An  
Bord  
Pleanála

**Board Direction**  
**BD-011810-23**  
**ABP-313302-22**

The submissions on this file and the Inspector's report were considered at a Board meeting held on 20/02/2023.

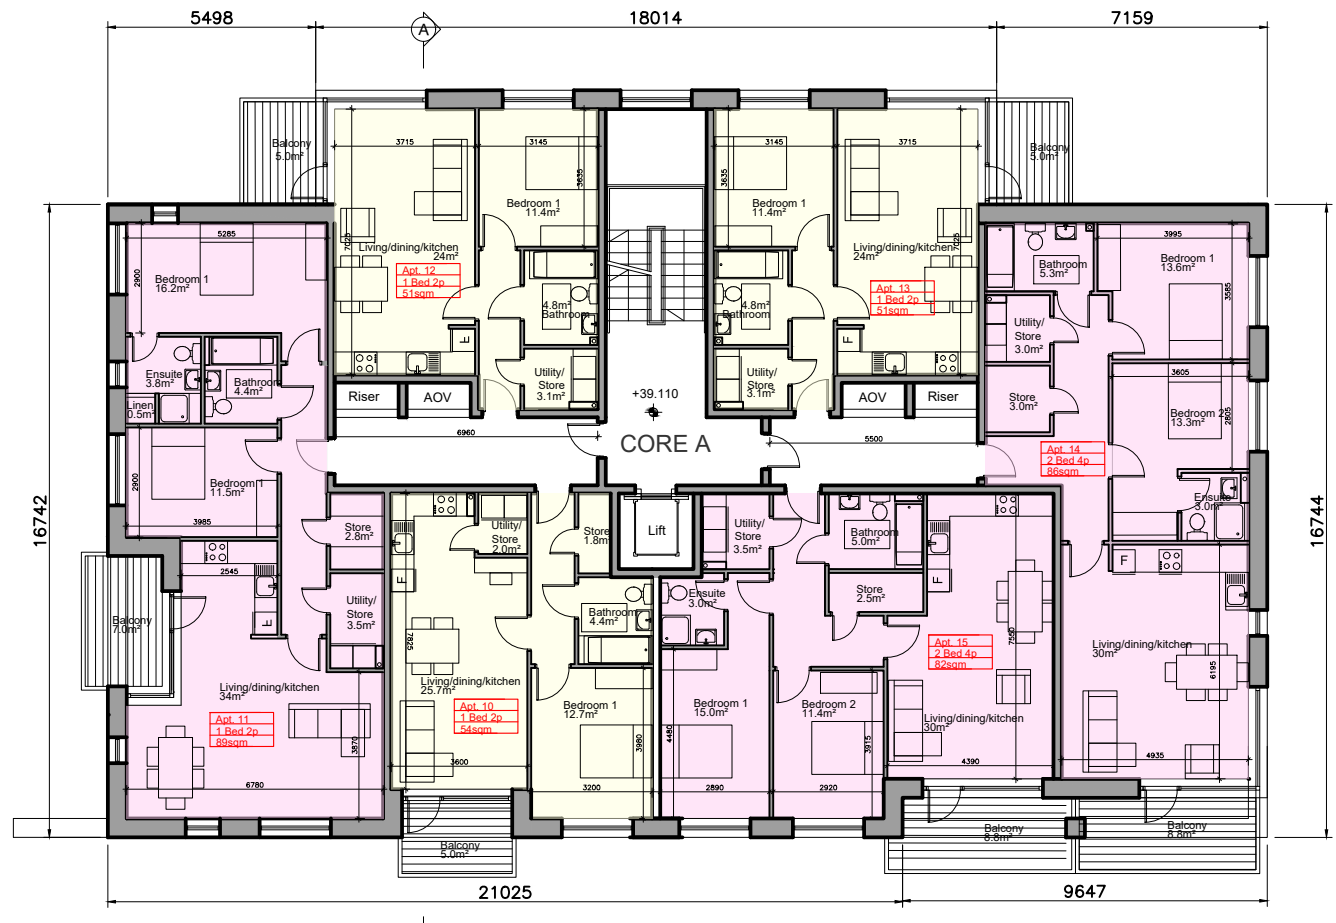
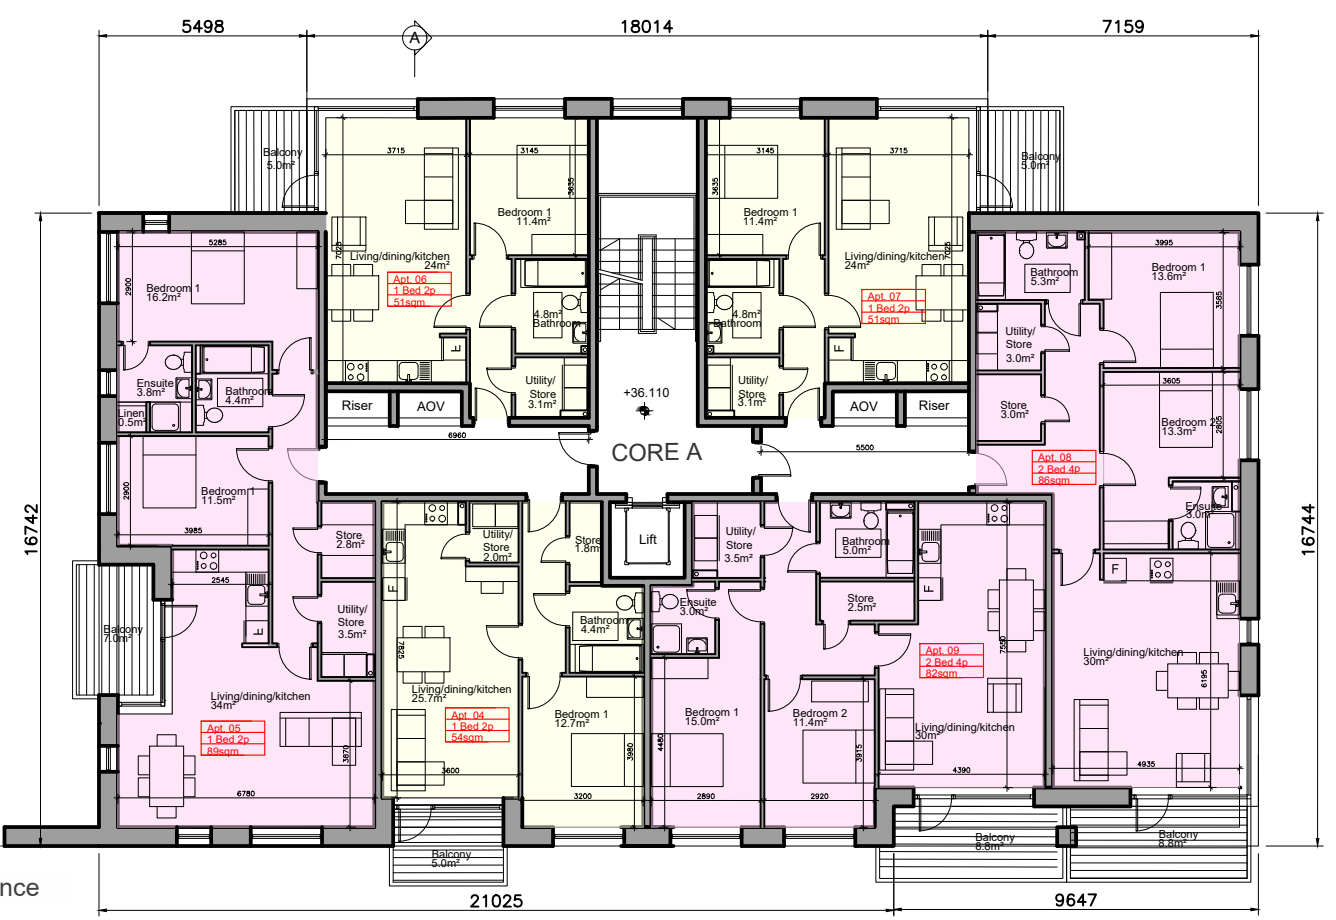
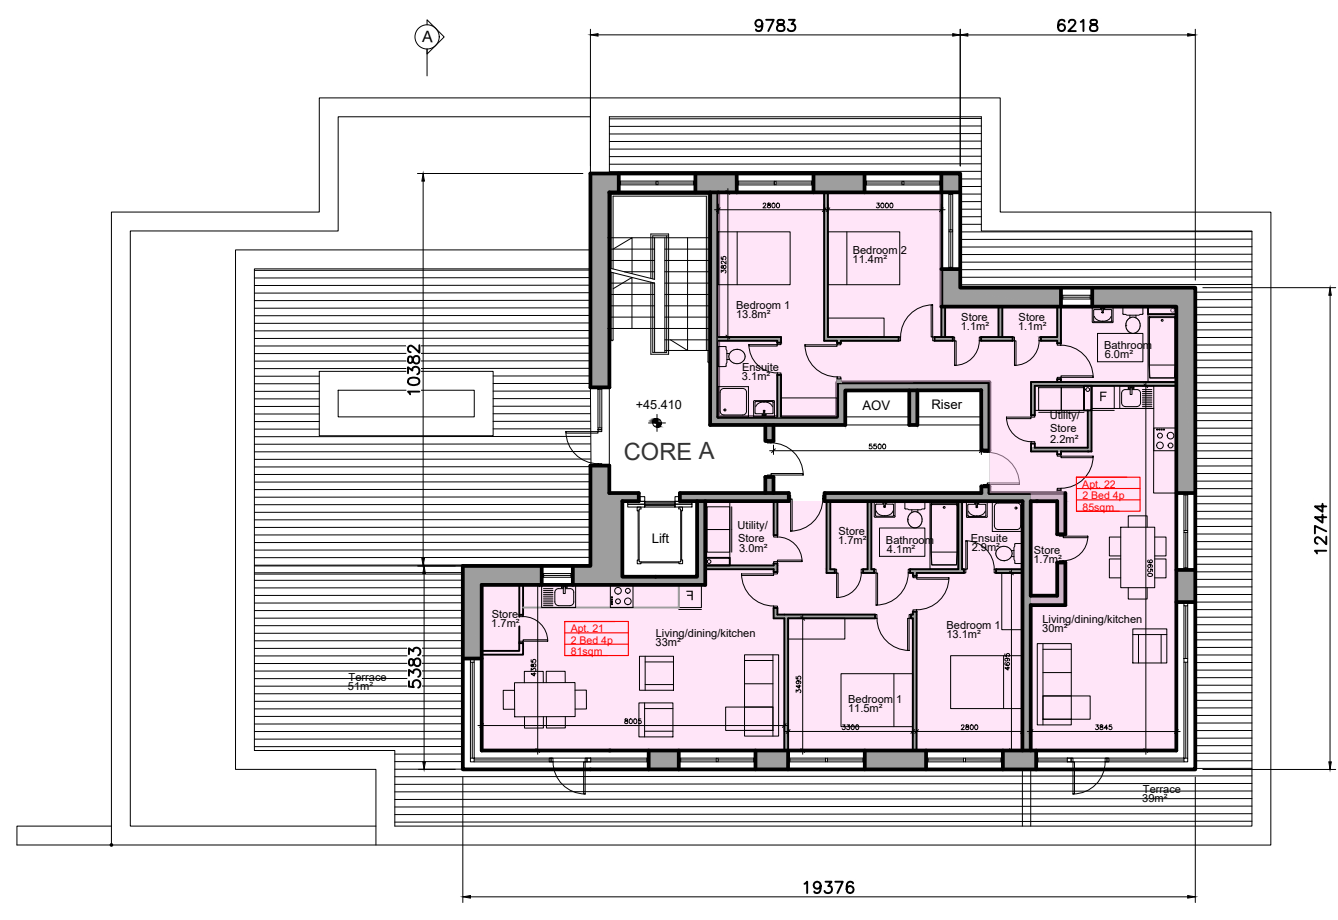
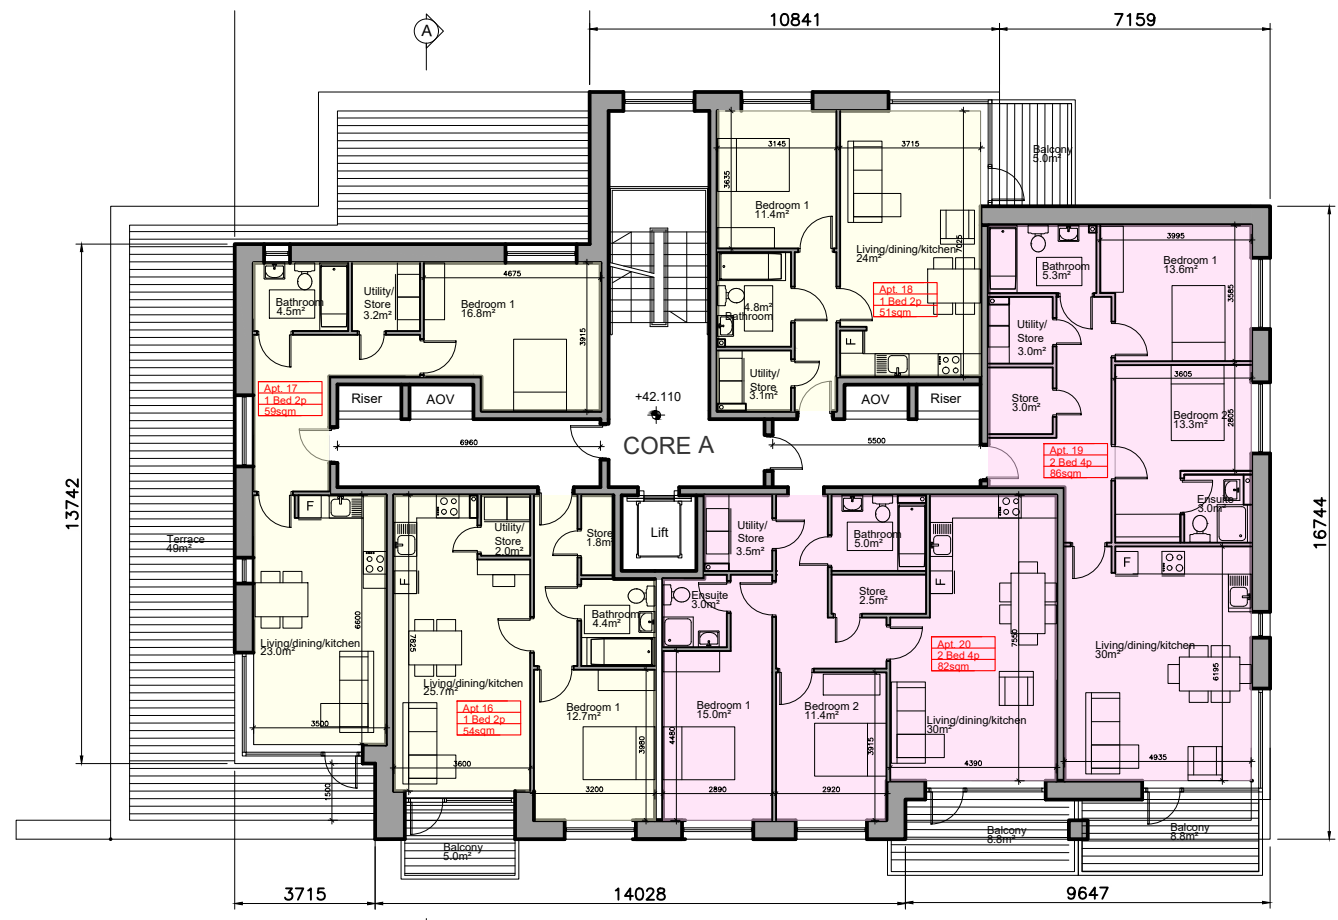
- (g) A door shall be provided between the bedroom and the external terrace in Apartment Number 17 in Apartment Block C.

Revised plans and particulars showing compliance with these requirements shall be submitted to, and agreed in writing with, the planning authority prior to commencement of development.

APARTMENT BLOCK C GROUND FLOOR PLAN

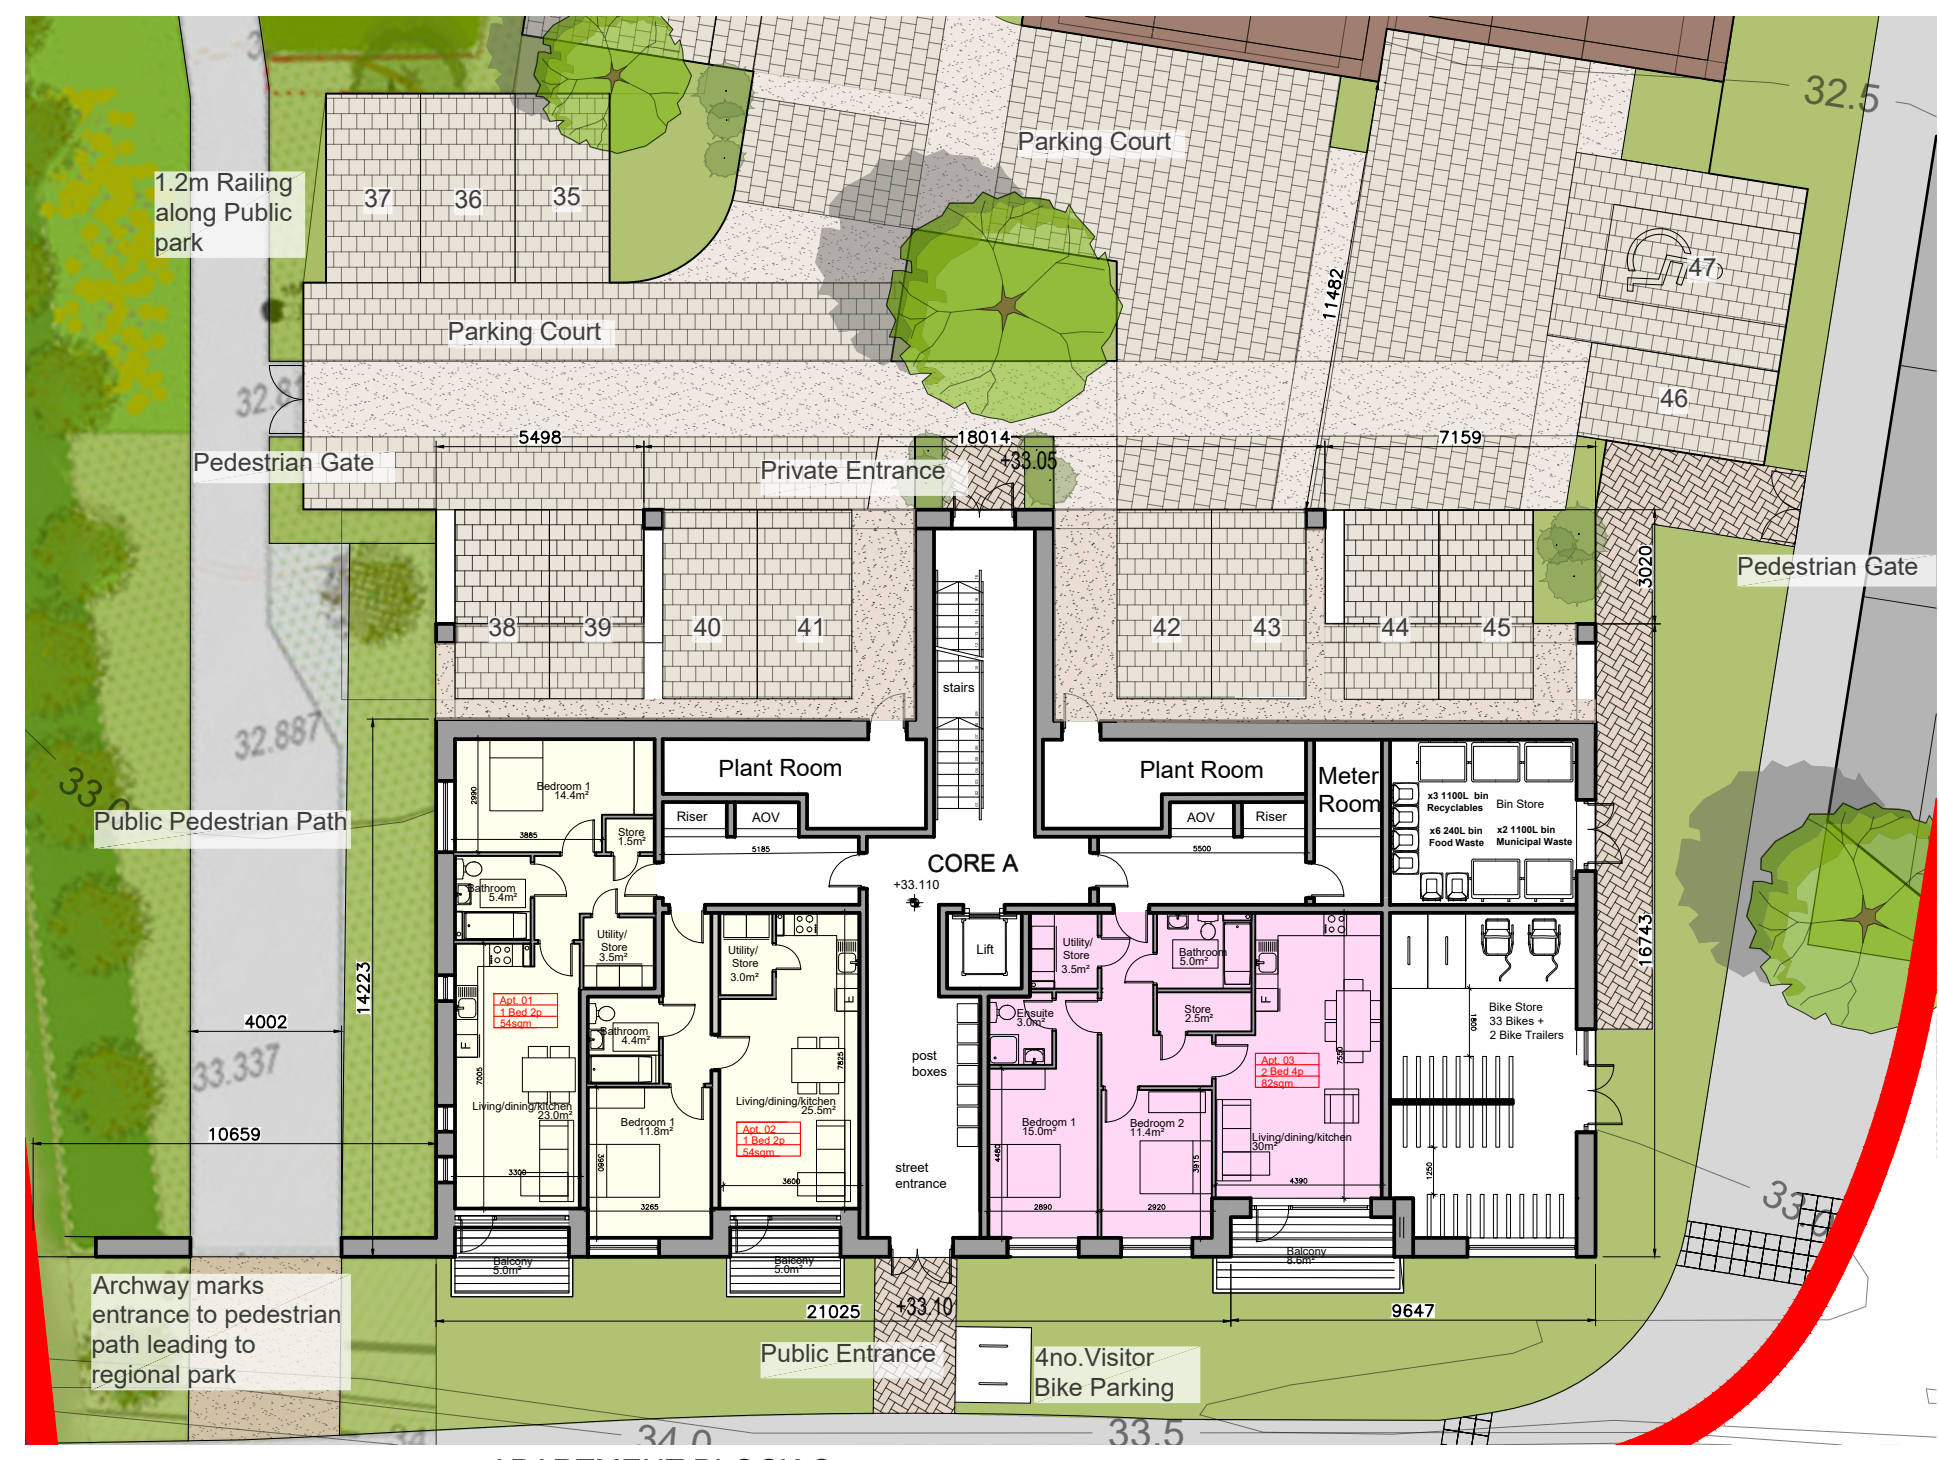
- (c) Apartment Numbers 01, 02, 03, 22, 23 and 24 in Apartment Block A; Apartments 01 and 02 in Apartment Block B1; Apartments 01 and 02 in Apartment Block B2; and Apartments 01, 02 and 03 in Apartment Block C shall be provided with own door access.
